**ADC Planning Consultation
Response from the Historic Buildings Adviser**

Application Number	FP/41/12/L
Address	Church House, 94 Felpham Road, Felpham
Description	COU from B1 to C3 and three new dormer windows to replace existing.
Case Officer	Susan Leeson
Site Visit

PROPOSED GROUND FLOOR PLAN
Scale 1:100

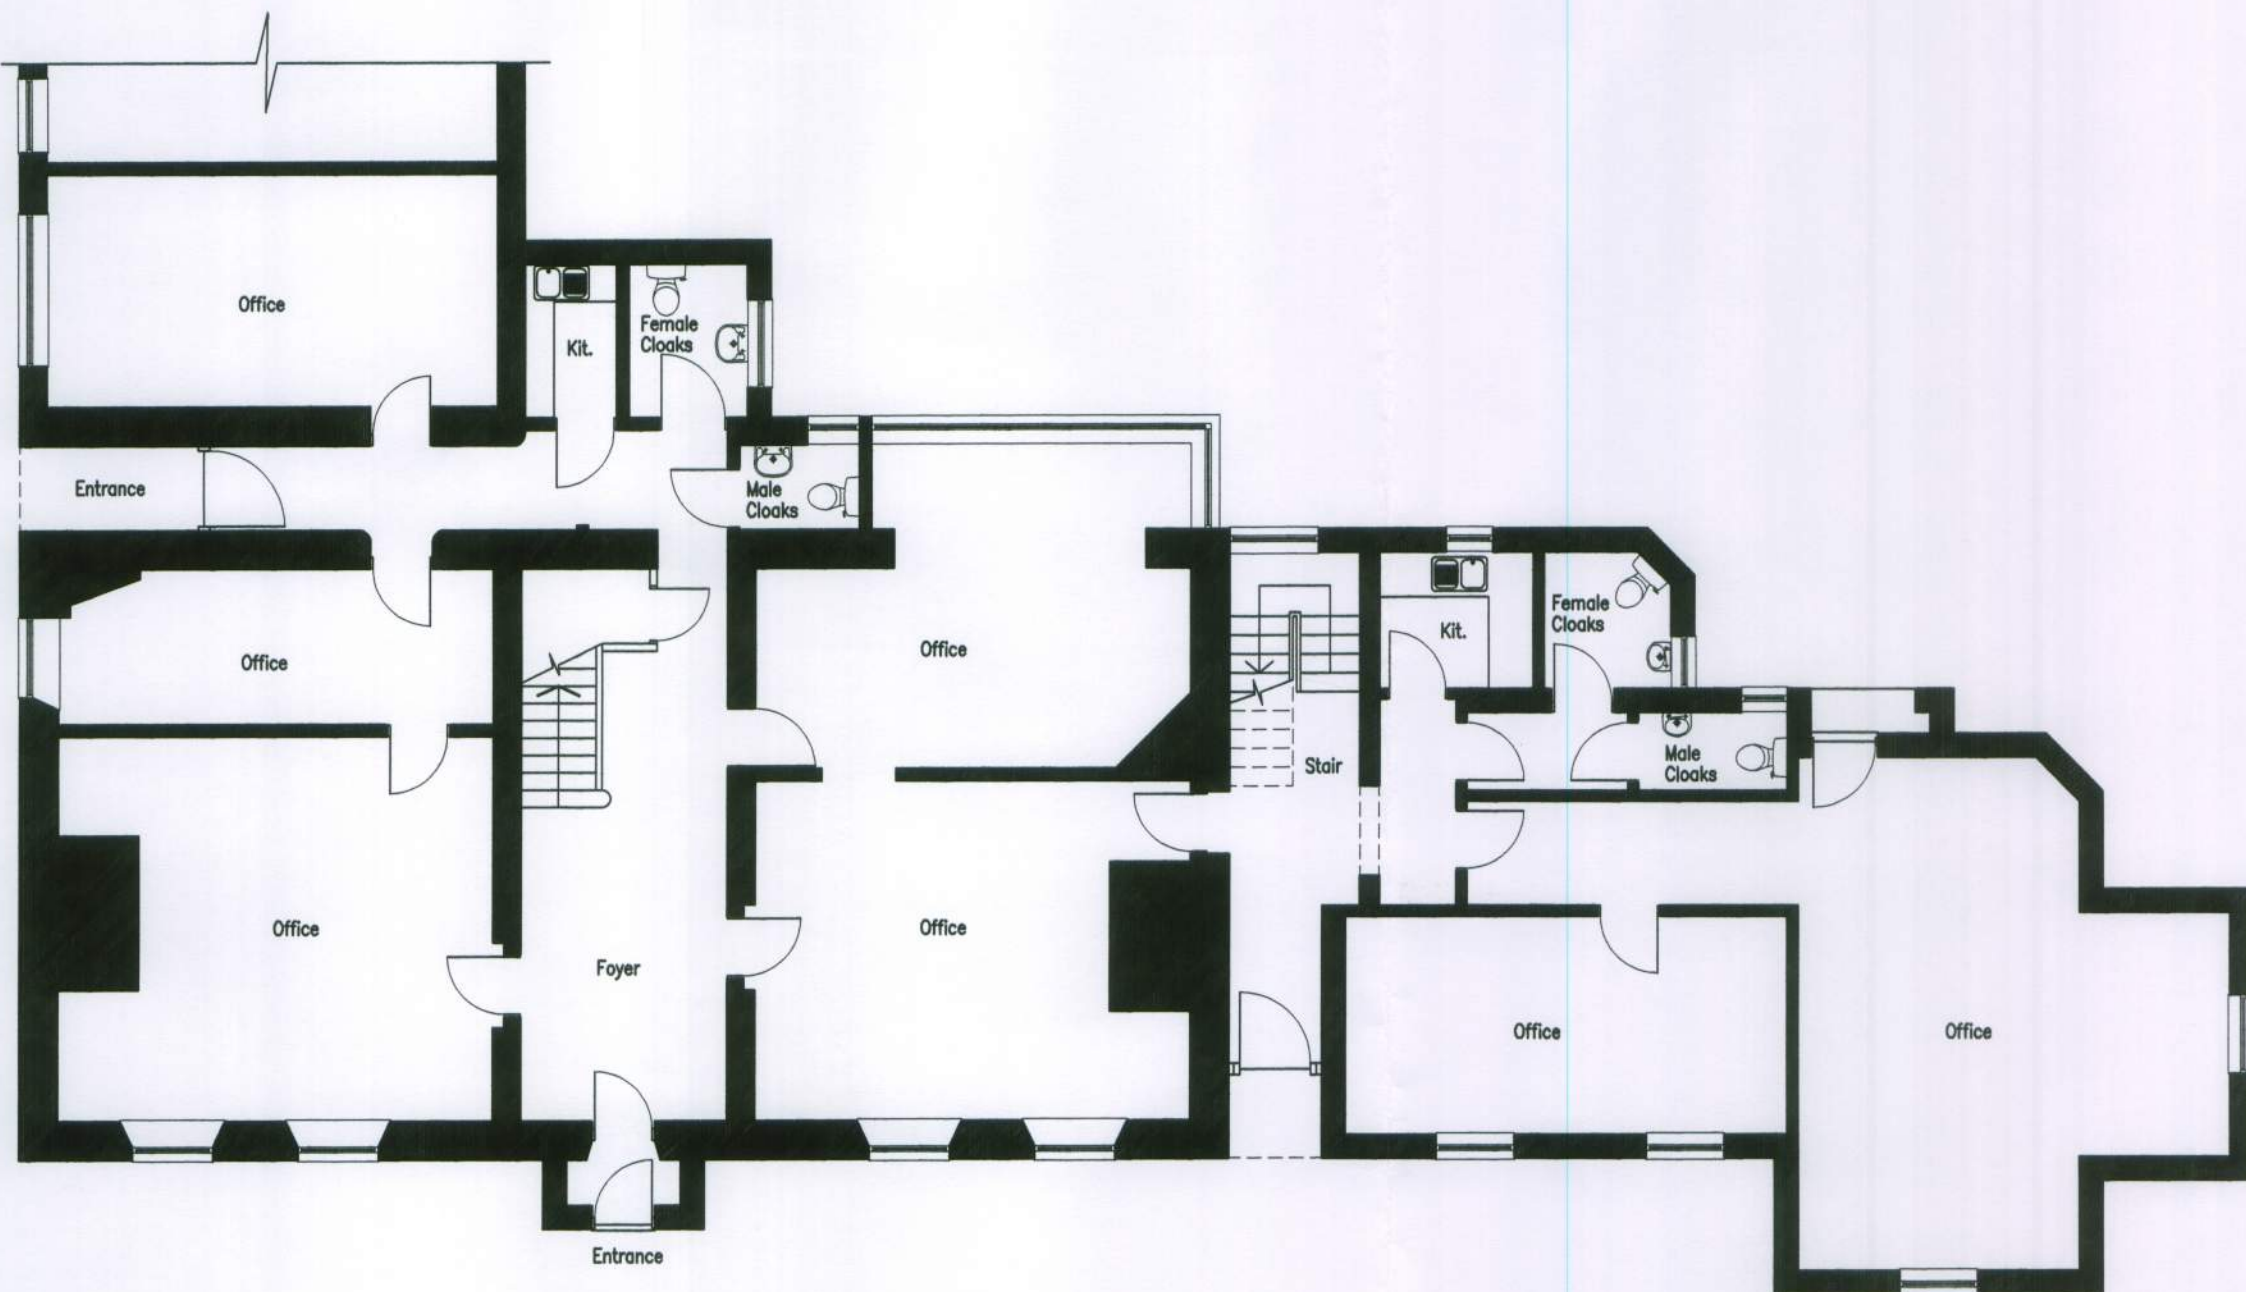
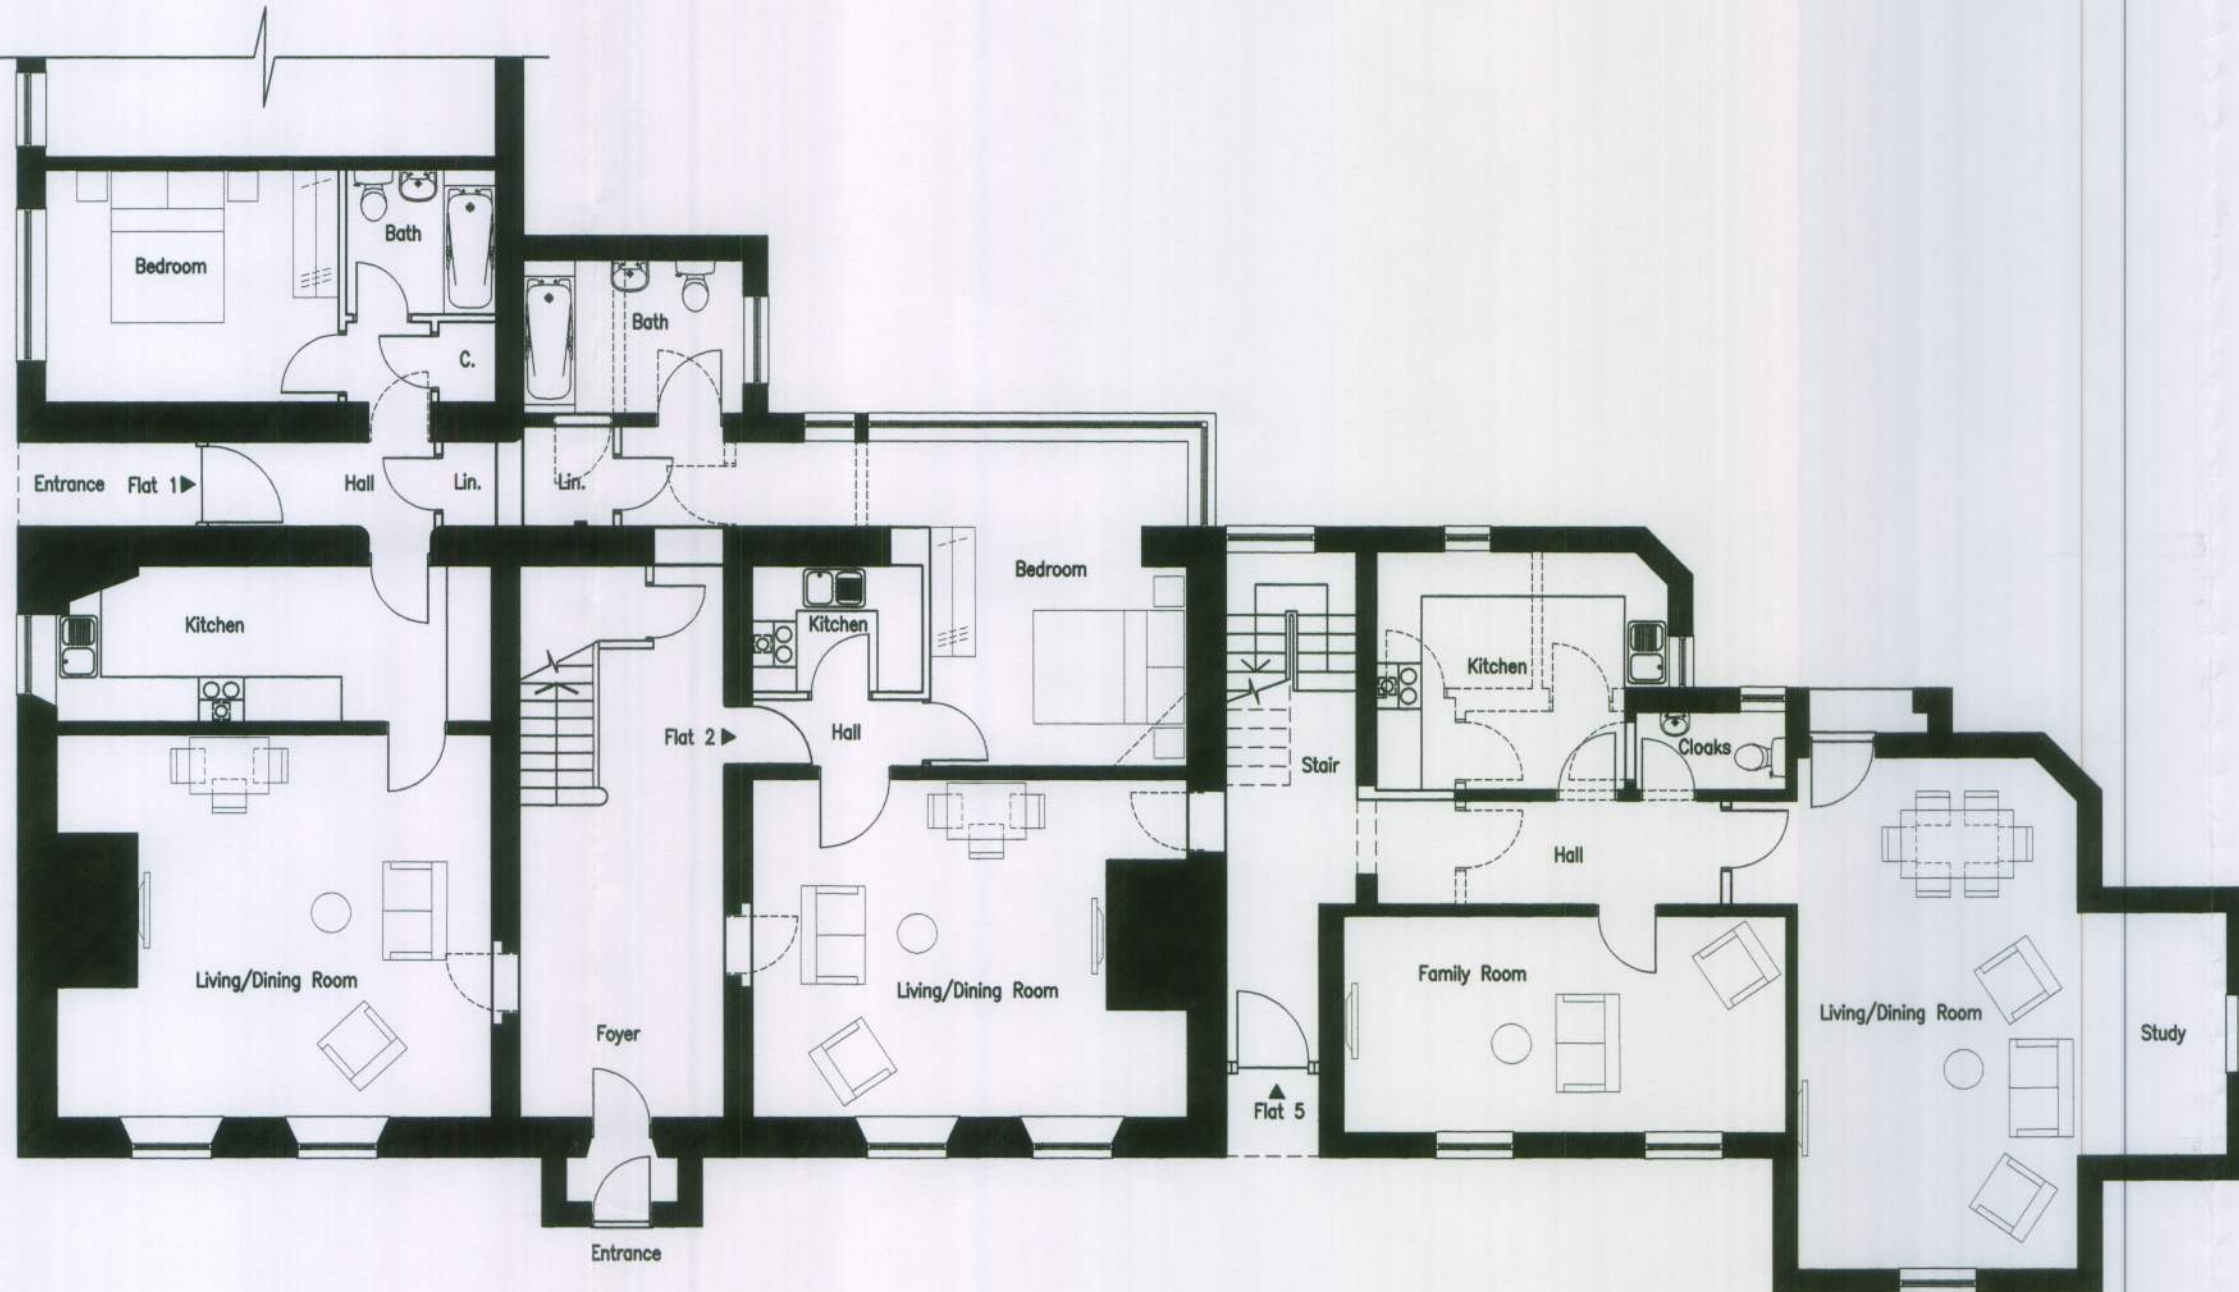
A more minor concern is the loss of the corner chimney breast in the rear ground floor. This can probably be justified if it is felt that this is the best use for the building and the most sustainable. Given that the building was formerly a house, I would have thought this reasonable. That said, we will require structural qualification for its removal as the breast above is being retained and will require support.

FRONT
PROPOSED ELEVATIONS
Scale 1:100

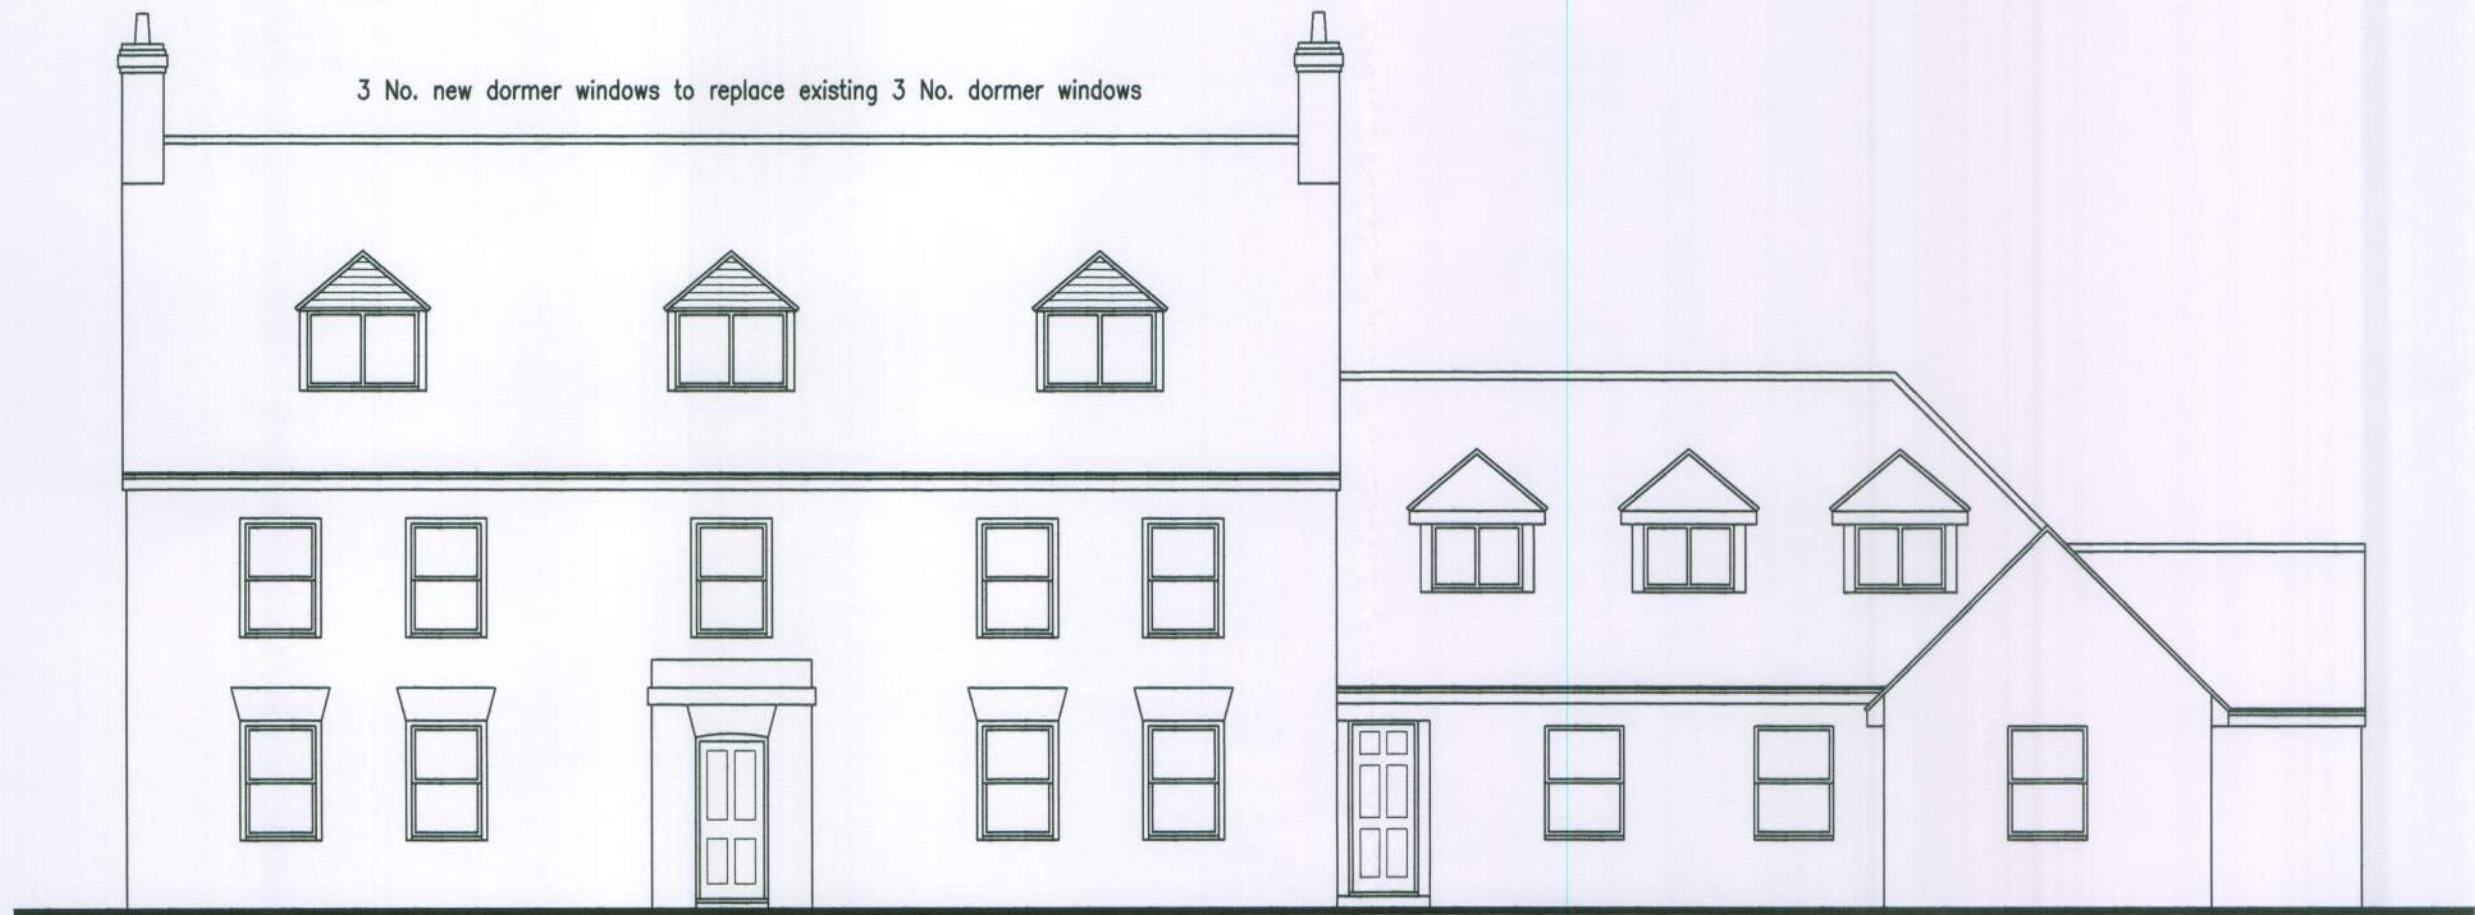
There is no objection to the principle of the change to residential use. The main issue here is the proposed dormer windows which are too large. They appear identical in size to the sashes below and as such introduce a scale and massing which is not appropriately subservient to the windows in the main elevation. This will make the fenestration appear top heavy which is likely to be even more pronounced when viewed 3-dimensionally. Unfortunately this will affect the character and appreciation of the listed building in a manner which is not acceptable.
